December 4, 2012

Re: Response to comments on the updated North Andalucia Drainage Master Plan (E12-D15)

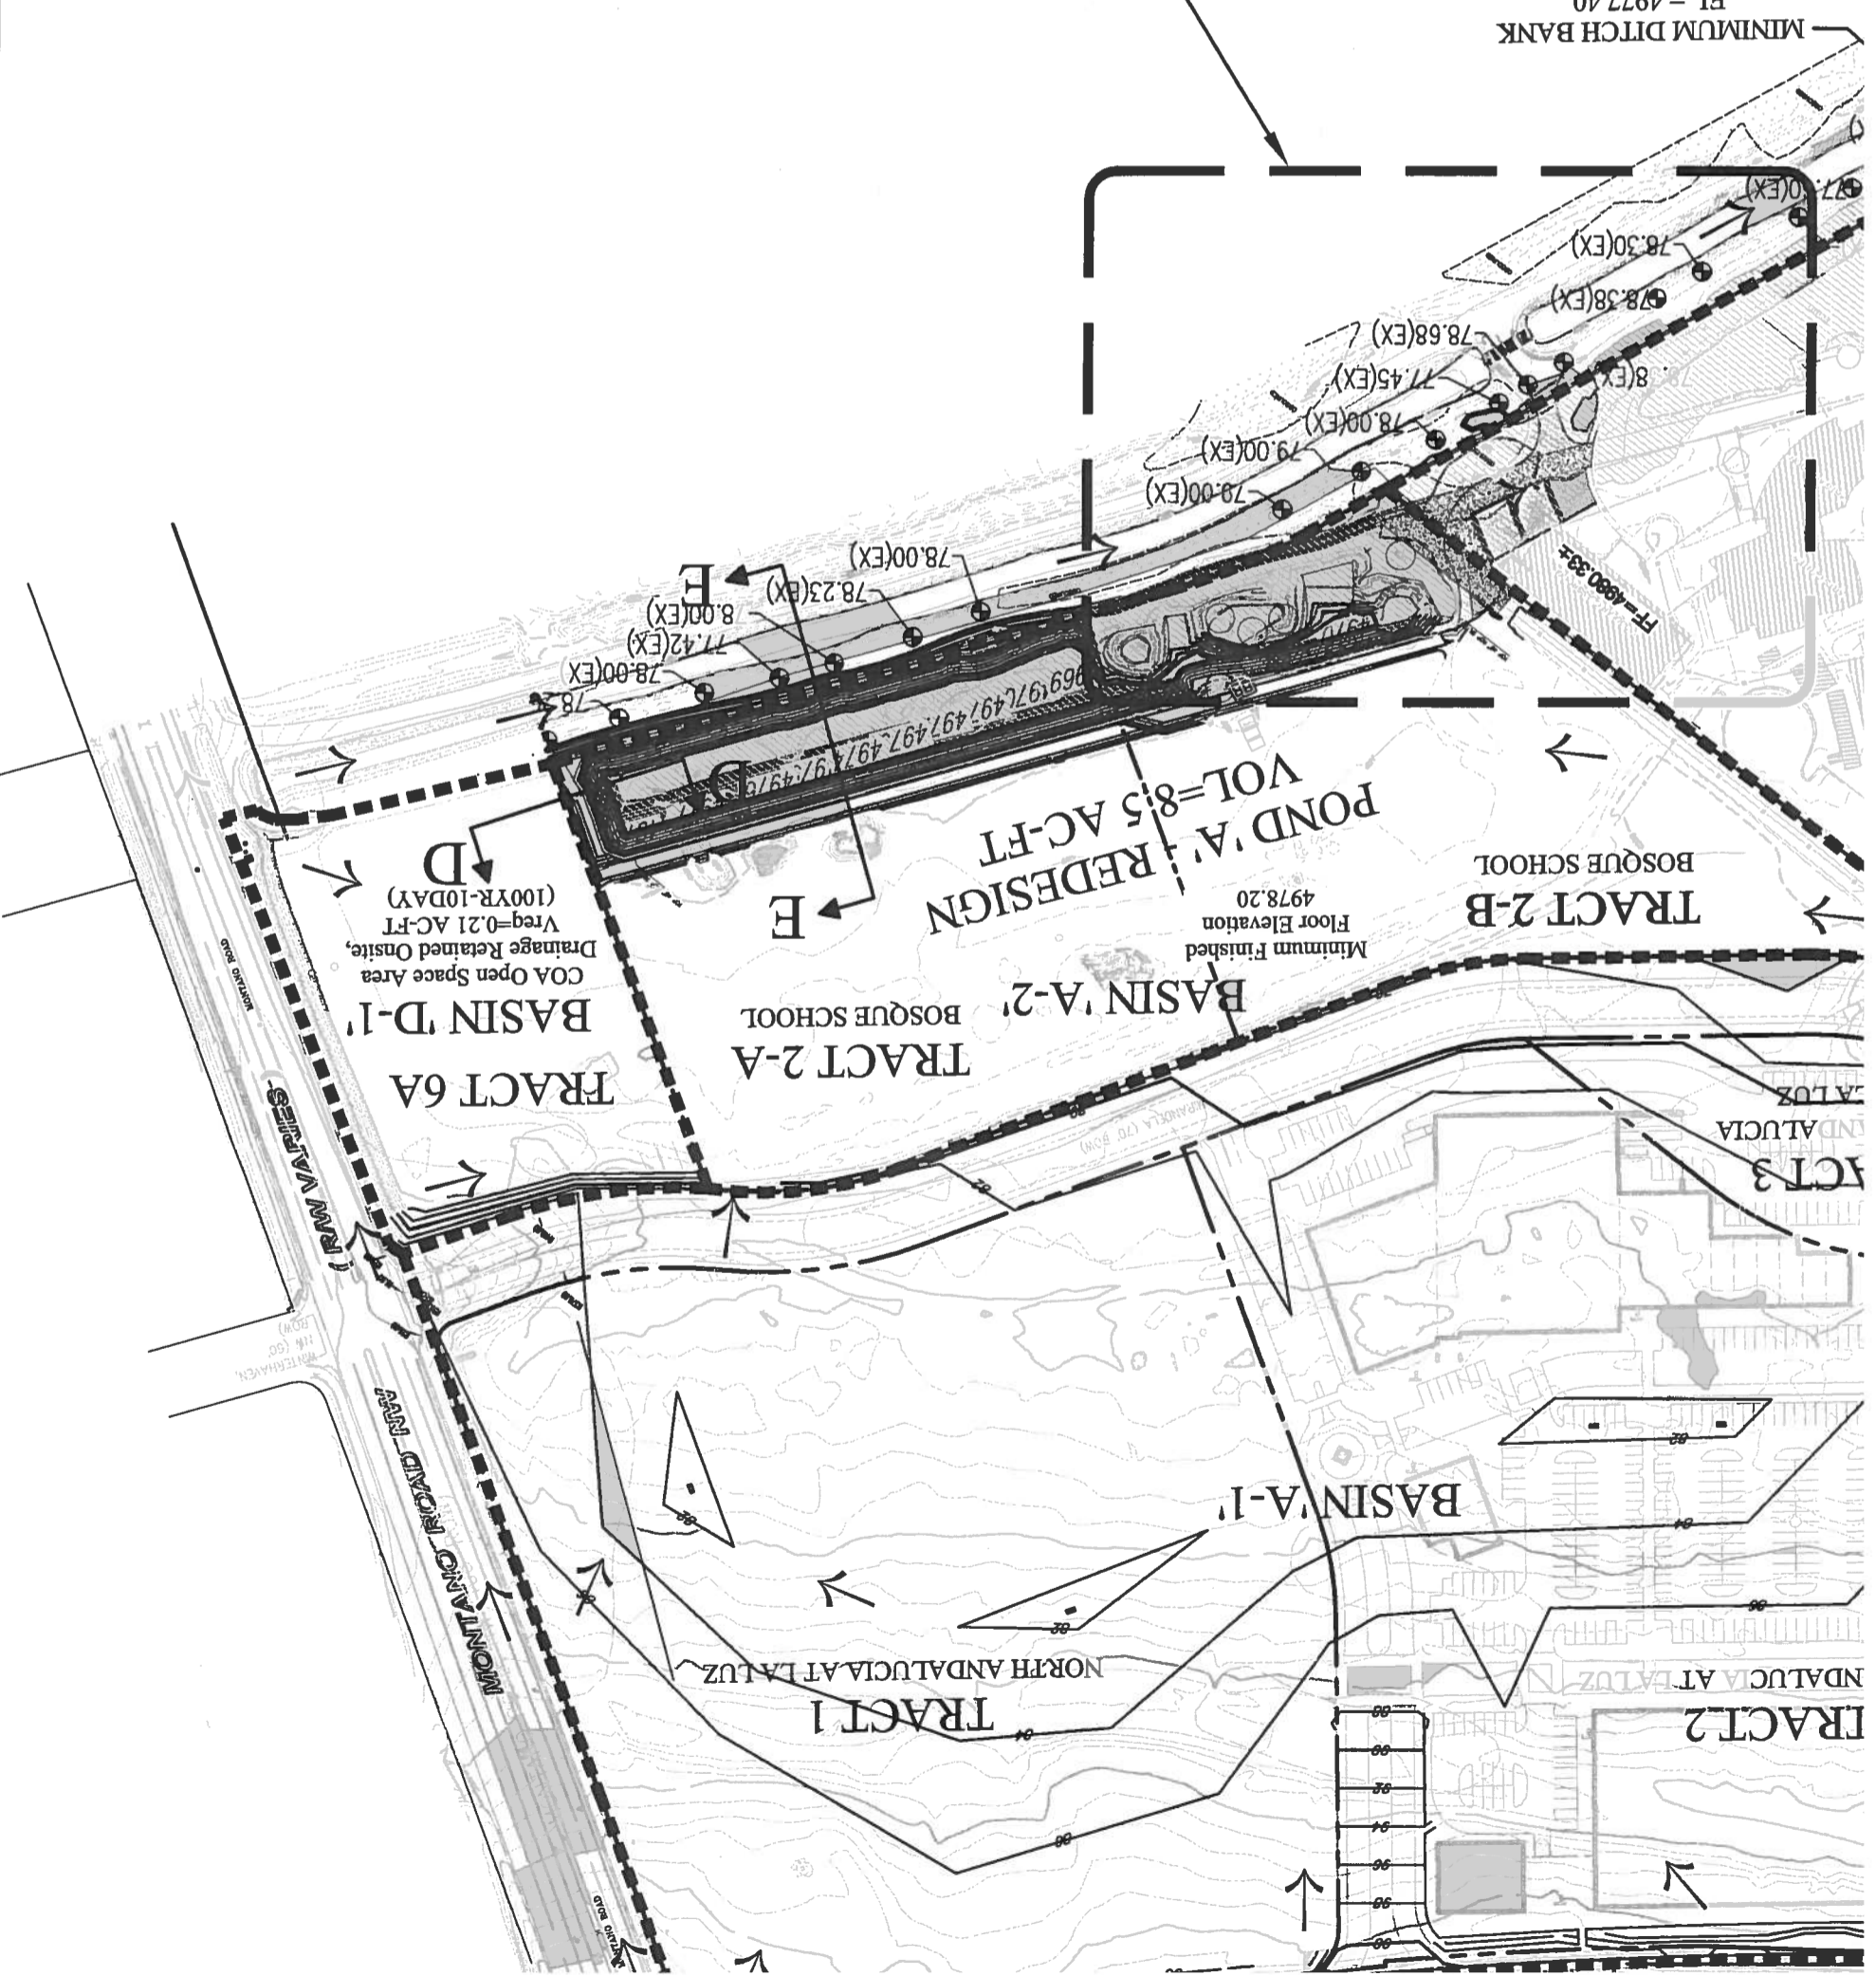
8. The Pond A limits and volumes will be confirmed and certified after the proposed modifications to Pond A are completed. Submitted with this plan is a detailed grading plan for the modifications to Pond A.

10. Detailed grading plans for Pond A and the spillway from Pond A to Pond B are included with this re-submittal. The groundwater elevation observed within the pond, and survey in the topographic survey prepared by Precision Surveys has been clearly labeled in Section E-E. I have also enclosed other groundwater level documentation from a geotechnical report and USGS. Both of these other sources suggest a lower groundwater elevation than the level observed at the bottom of the existing pond. Accordingly, we are using the most conservative elevation – based on the observed and surveyed water surface.

11. The spillway concerns have been addressed as follows:
  - a. Horizontal Control information has been provided on the detailed grading plan.
  - b. Build notes, cross sections and details have been provided.

- c. Section B has been clarified to show the existing modular building.
12. No modifications to Pond B are proposed – other than at the location where stormwater would overflow from Pond A to Pond B. The volume calculations given in the DMP are based on a 1' contour interval topographic survey prepared by Precisions Surveys, and attached herewith. The minimum ditch bank elevation was clearly labeled on the plan, but it occurs in more than one location, so we have added another label to clearly show both locations.
